## **OXFORDSHIRE COUNTY COUNCIL'S RESPONSE TO CONSULTATION ON THE FOLLOWING DEVELOPMENT PROPOSAL**

**Application no:** 24/01769/F

**Proposal:** Engineering work in association with the formation of the Bus Loop serving the development previously approved under 18/00825/HYBRID.

**Location:** Land West Of, 70 Hampden Square, Heyford Park

REV	DESCRIPTION	DRN	CHD	DATE
1	PRELIMINARY			
2	INFORMATION			
3	TENDER			
4	CONSTRUCTION			
5	AS BUILT			
SCALE	1:1000 @ A0	DATE	JUNE 2024	
DRAWN	AT	CHK	JF	
DRAWING NO.	HEYF-5-1694	REV	-	
TITLE	UPPER HEYFORD CHILGROVE DRIVE			
DETAILS	GENERAL ARRANGMENT WORKS WITHIN PHASE 2

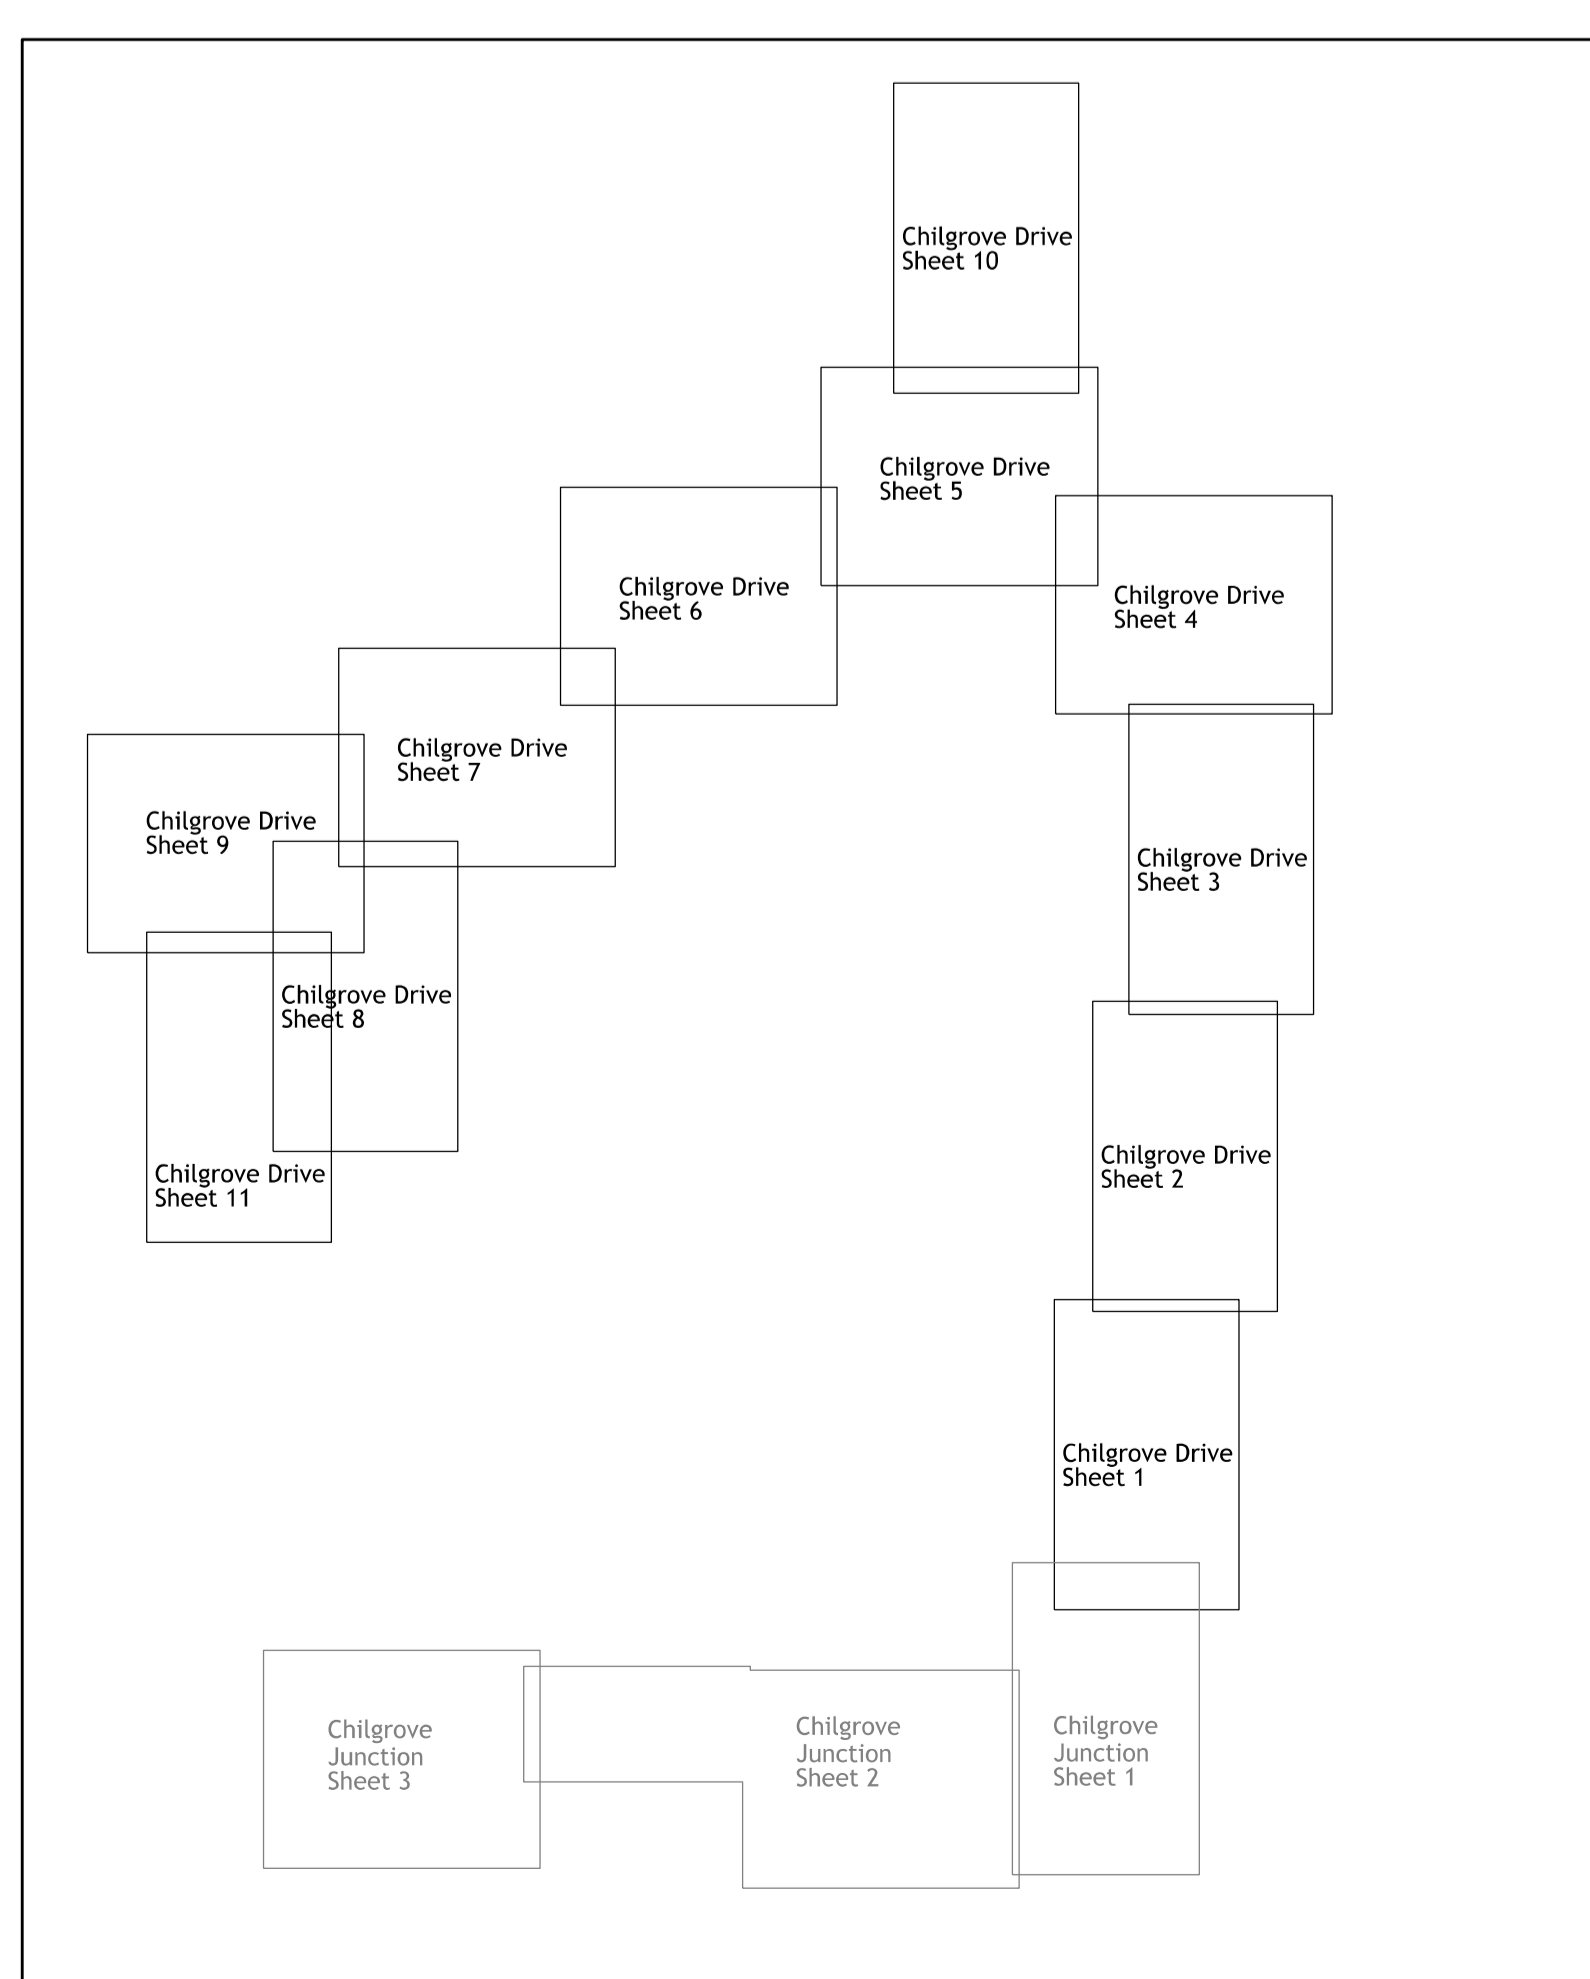
Insufficient drainage information has been submitted. The applicant should submit all information required in the Oxfordshire County Council Local Standards Appendix D: Information required for full planning application
